DRAINAGE REPORT

**Town of Ramah Wastewater
System Improvements**

DATE: October 27, 2023

**Please add "PCD File No.
PPR2325"**

PROPOSED DRAINAGE PLAN

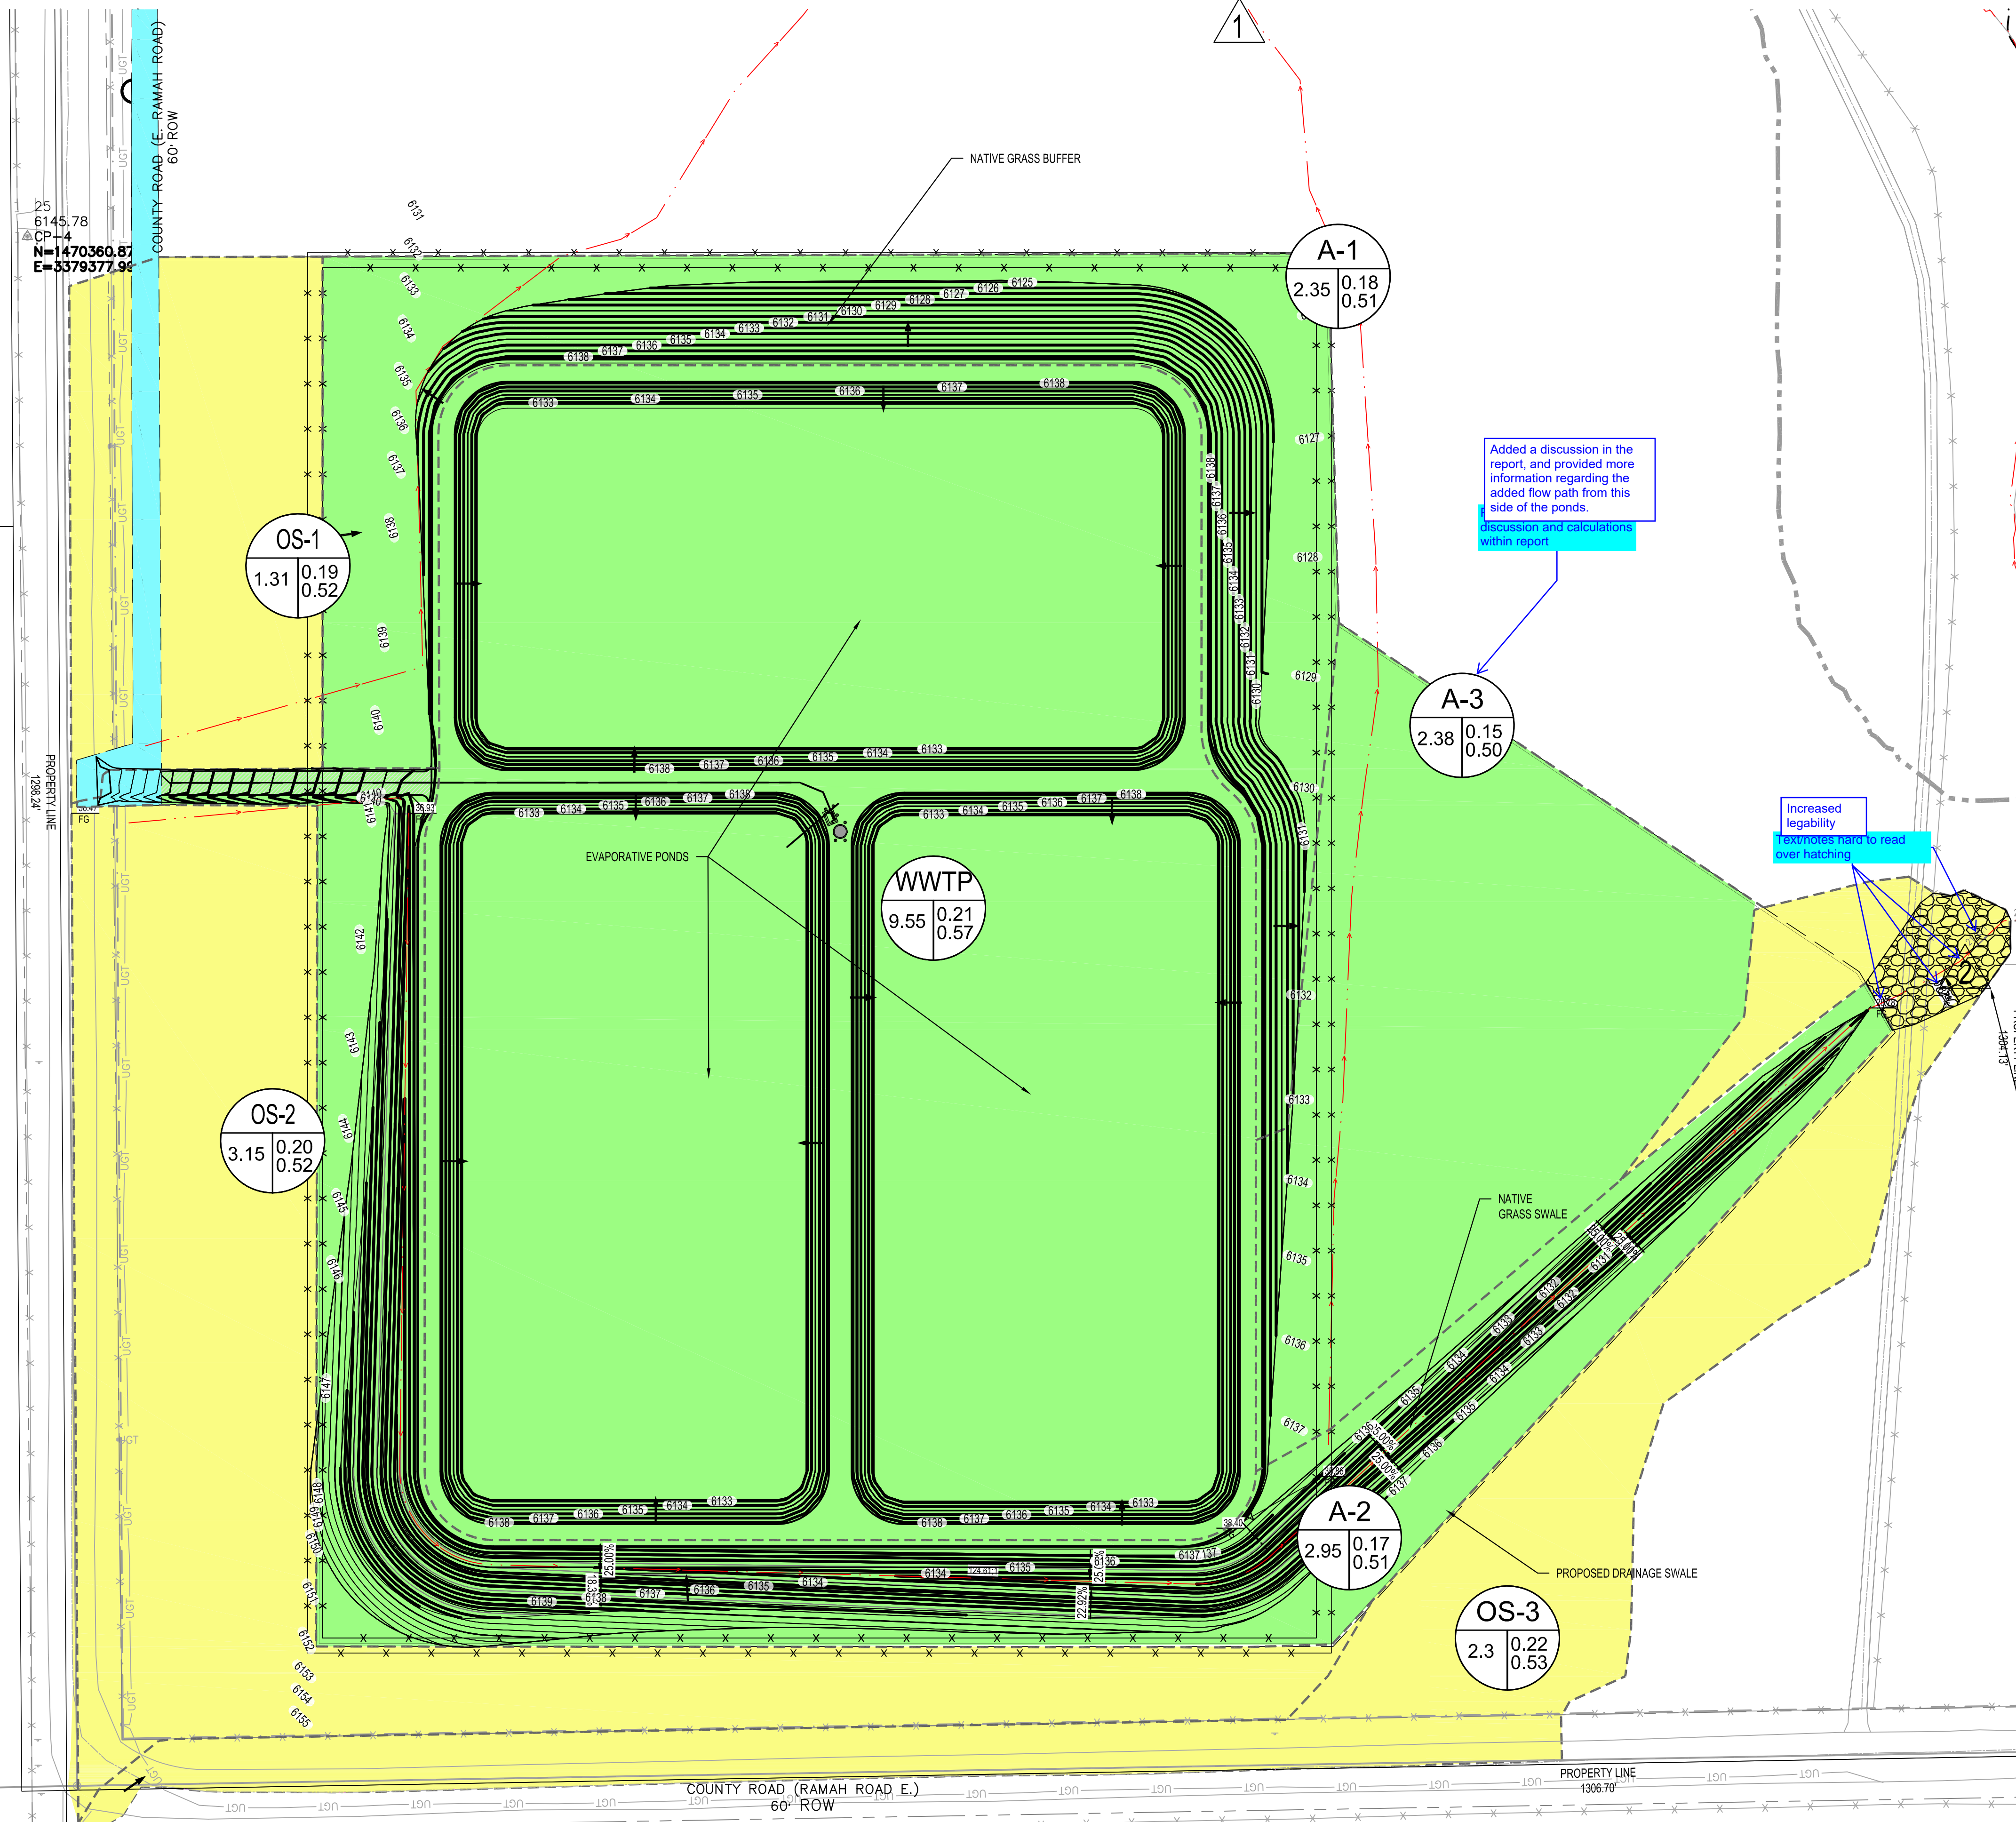
There are two types of flow paths from the site, and these are labeled on the drainage plan a path 1 and 2.

Please include calculations for proposed ditch located near the lift station and provide the minimum size and slope required for the ditch to adequately handle flows.
